**FLOOD RISK RELATED COMMENTS ON DEADLINE 3
SUBMISSIONS IN RESPECT OF SCOTTISH POWER
RENEWABLES EA1N AND EA2 PROJECT ONSHORE
WORKS NEAR FRISTON**

**For
SASES**

January 2021

Report Number: 210110

East Anglia ONE North and TWO Outline Operational Drainage Management Plan Surface Water Flood Risk

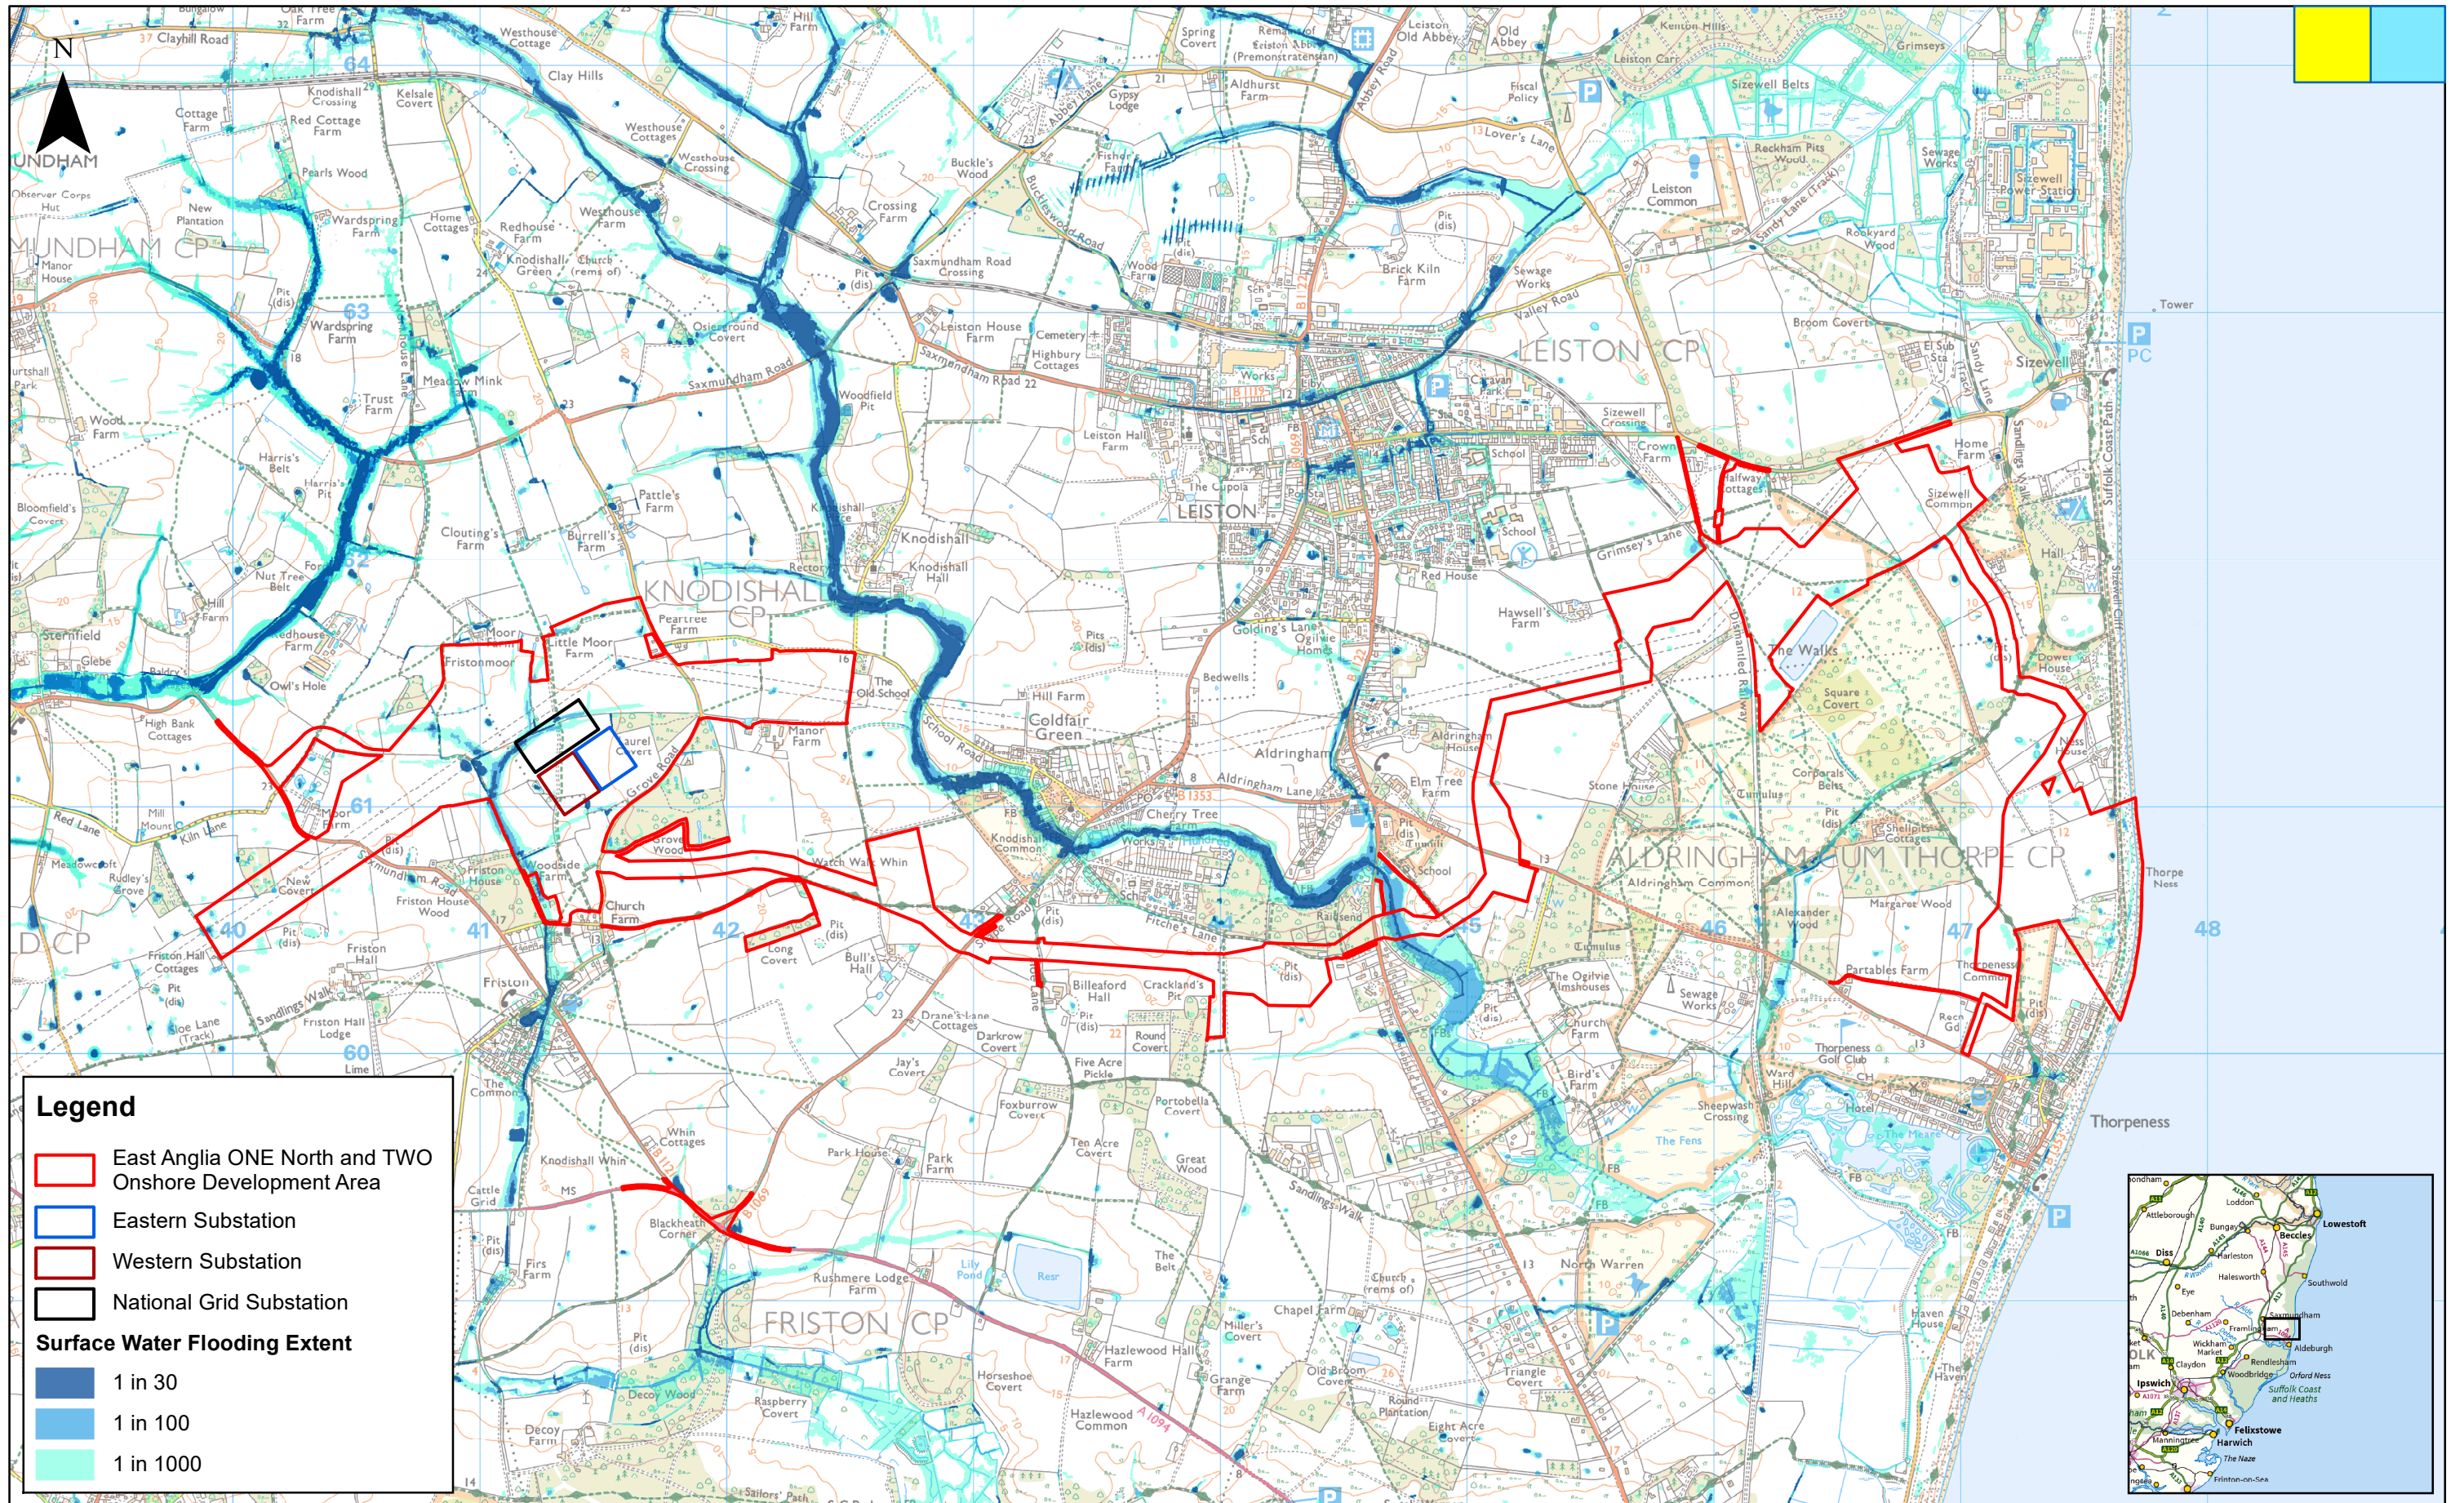
The Applicant has also included a surface water flood risk map, which clearly shows the overland flow routes hydraulically linking the proposed development site to the water courses flowing through Friston Village.
